City of Portland, Maine - Building or Use Permit Application
 389 Congress Street, 04101 Tel: (207) 874-8703, Fax: (207) 874-8716

Permit No: 04-1601	Issue Date:	CBL: 084 L007001
------------------------------	--------------------	----------------------------

Location of Construction: 33 Island Ave	Owner Name: Island Acquisition Llc	Owner Address: 50 Monument Sq	Phone:
Business Name:	Contractor Name: Owner	Contractor Address: Portland	Phone
Lessee/Buyer's Name	Phone:	Permit Type: Alterations - Commercial	Zone:

Past Use: Commercial / residential	Proposed Use: commercial / residential expand studio add stair Change use from hardware to restaurant/bar add new exit and exterior ramp.	Permit Fee: \$1,821.00	Cost of Work: \$200,000.00	CEO District: 2
Proposed Project Description: expand studio from 2nd floor into 3rd floor, add stair to bedrooms and bathrooms from studio. Change of use from hardware store to restaurant & bar and build exit from restaurant space with exterior ramp.		FIRE DEPT: <input type="checkbox"/> Approved <input type="checkbox"/> Denied	INSPECTION: Use Group: Type	
		Signature:	Signature:	
PEDESTRIAN ACTIVITIES DISTRICT (P.A.D.)				
Action: <input type="checkbox"/>

A0	2ND FLR. PLAN	Date 9/22/04	Scale see drawing	ARCHETYPE, P.A. ARCHITECTS 48 Union Wharf Portland, Maine 04101 (207) 772-6022 Fax (207) 772-4056	Project PEAKS ISLAND INN PEAKS ISLAND PORTLAND, MAINE	Owner ISLAND AQUISITION 46 NEWBURY STREET PORTLAND, MAINE 04101
		Drawn By: 10-22-04	Checked By:

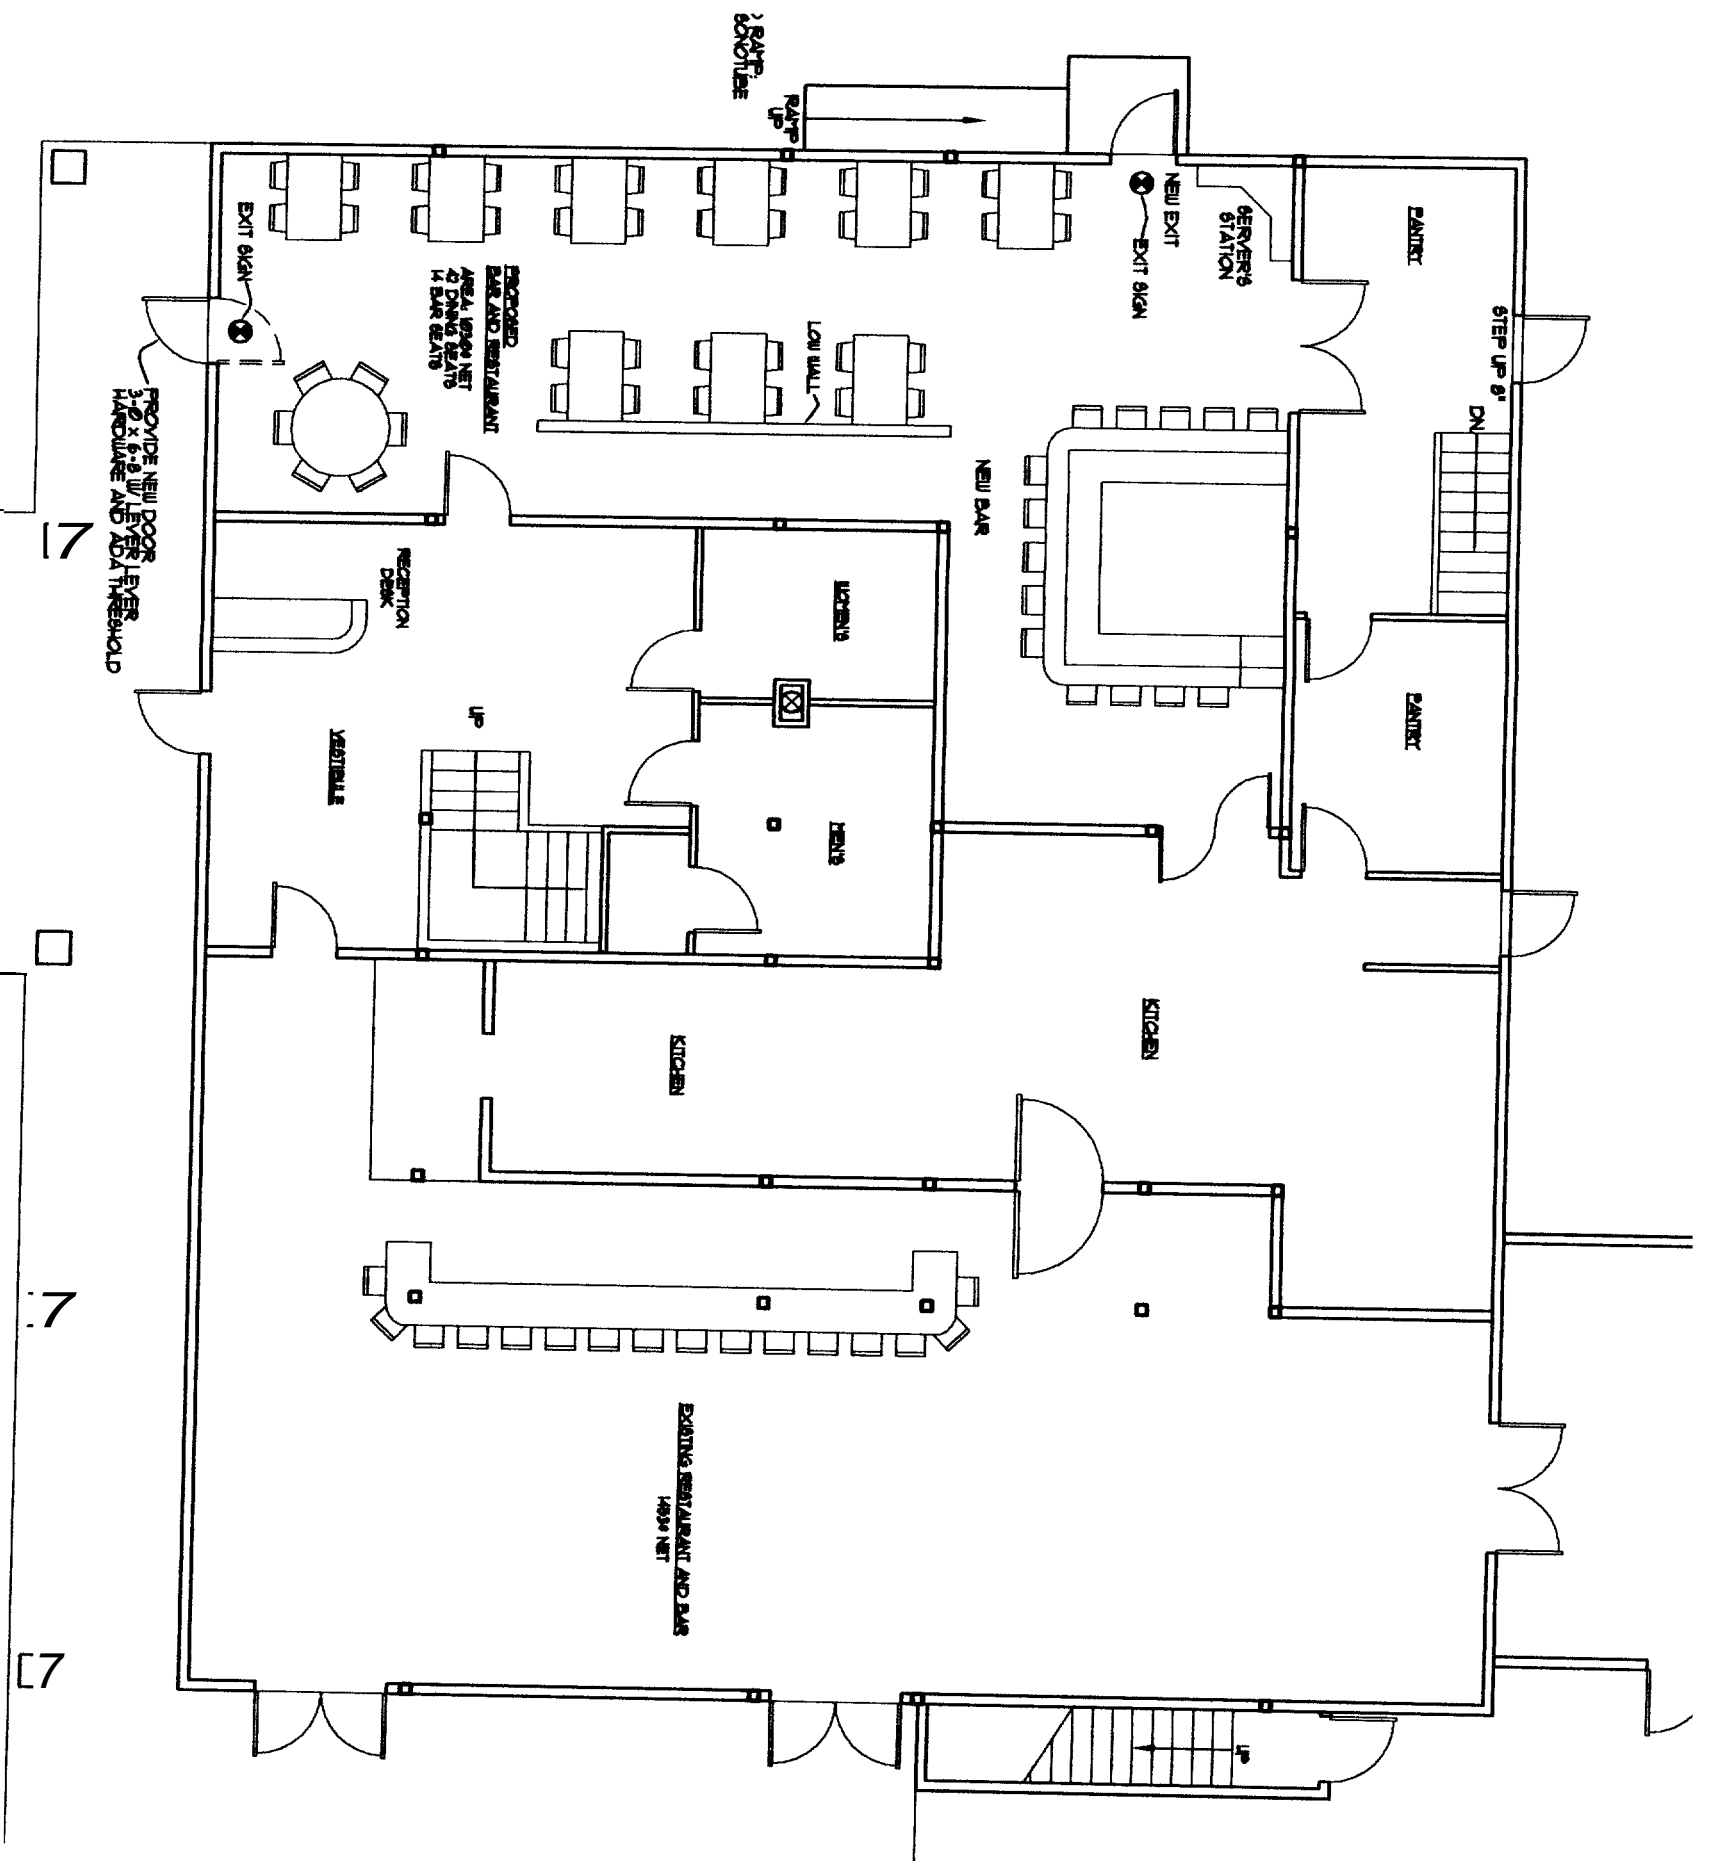
- 1) Exterior stairs must not have nosings, One sky light in each sleeping room must comply with egress standards

Joe Chalal agreed to both of these conditions this date! MJN

3 STAIR SECTION/ELEVATION
1/4" = 1'-0"

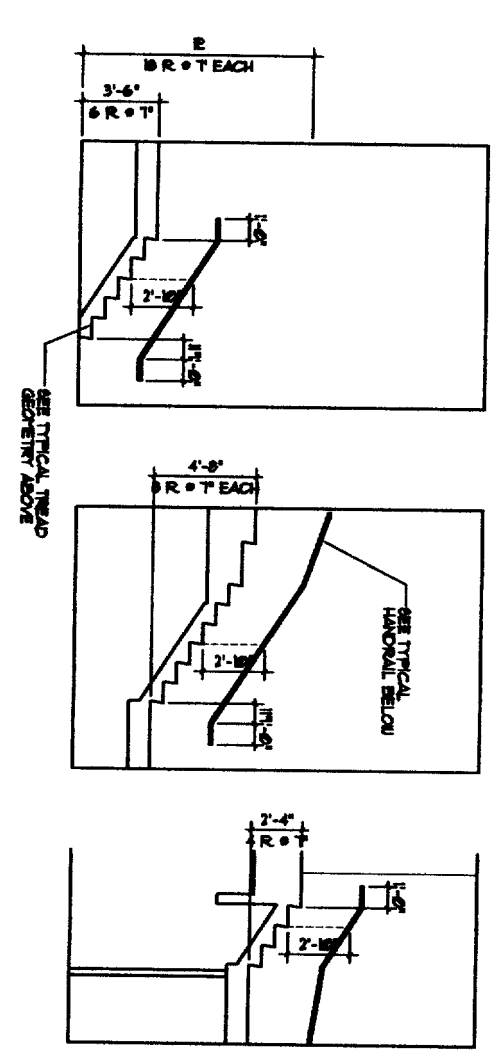
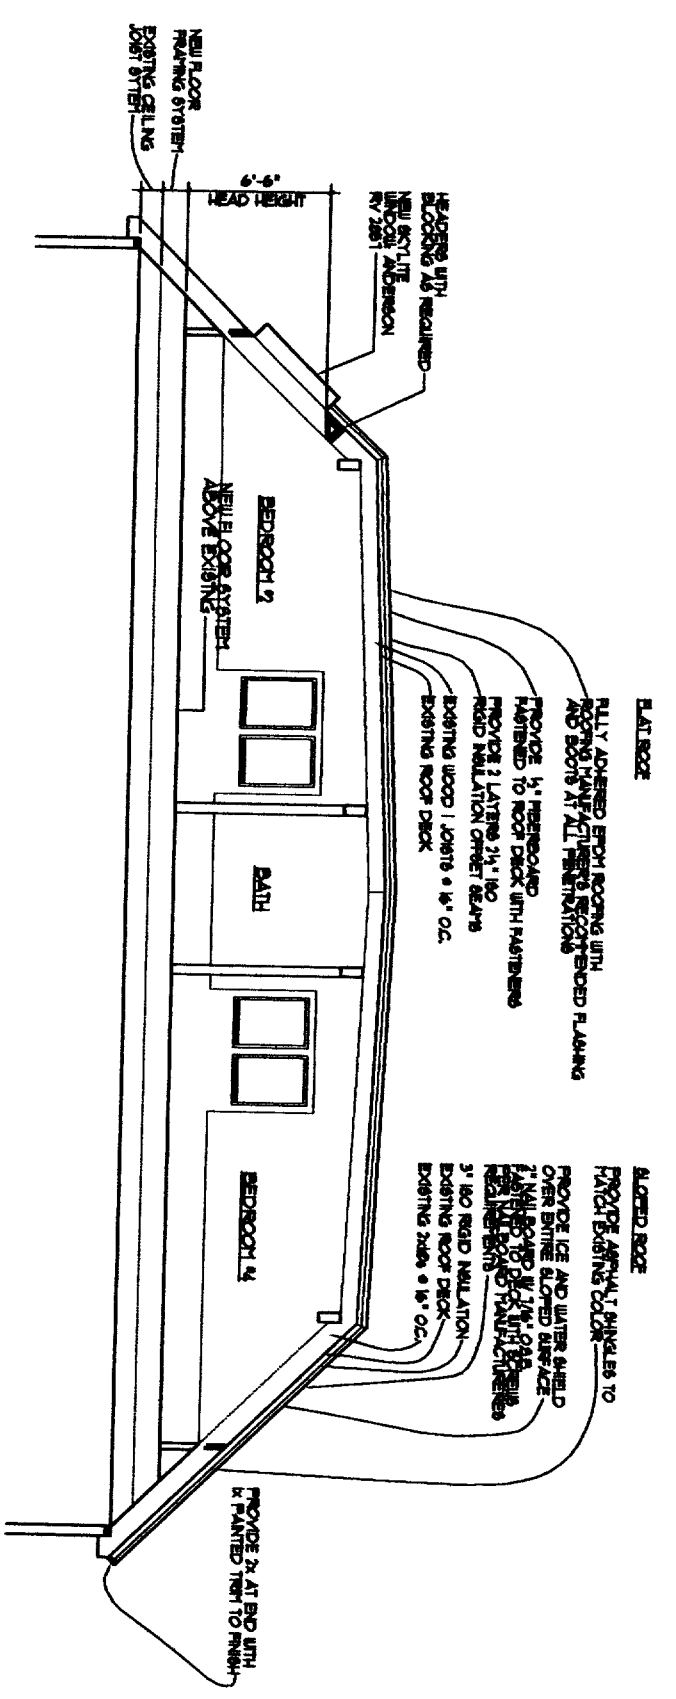
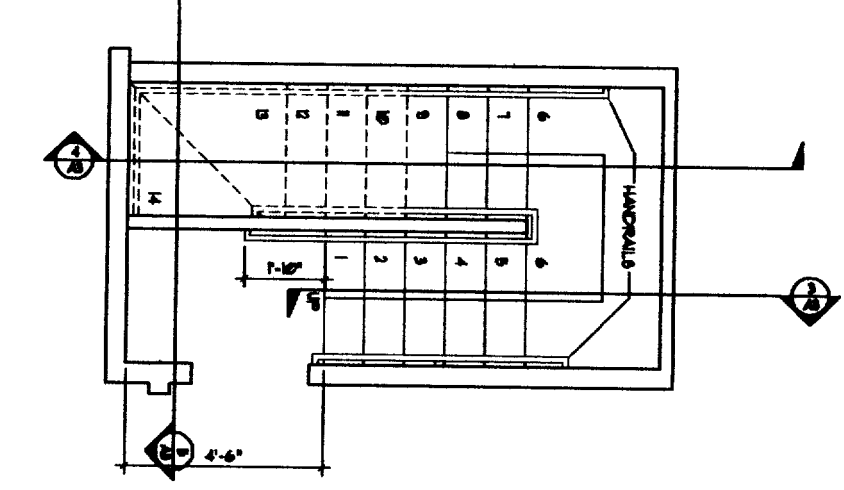
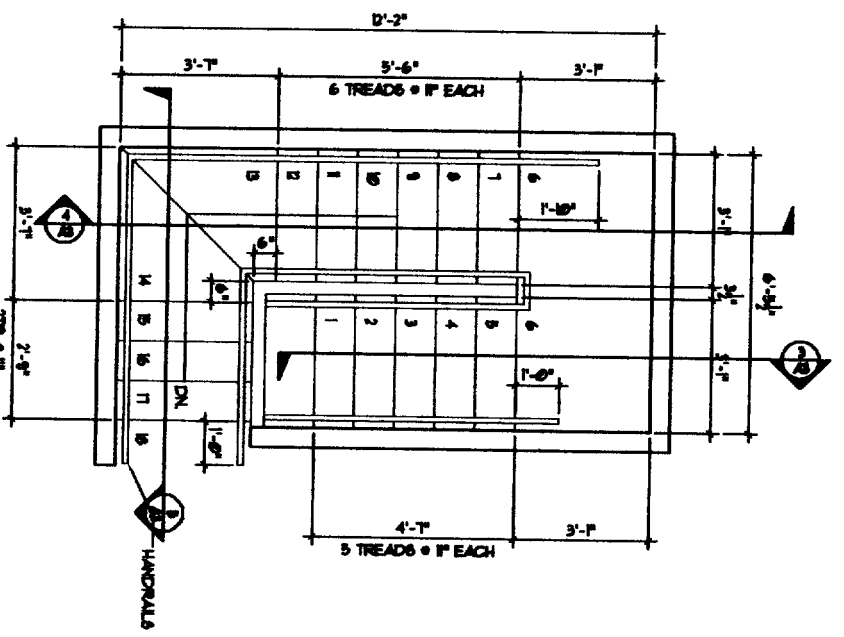
- 12/02/2004-mjn: 1) Construction details for the new ramp, landing and guards. Header detail for the new door.
2) Framing details for the new stairs including the Guard demising wall.
3) Floor ceiling assembly penetration protection plan
4) The new Floor/Ceiling fire separation assembly must have a one hour rating if the fire supression system is not a full NFPA 13 system (I think it was a 13R system). Please show that section w/ UL listing and STC rating.
5) Statement of Special Inspections for the Steel work as required in Section 1704.
6) What are we doing for Fire supression in the new area?
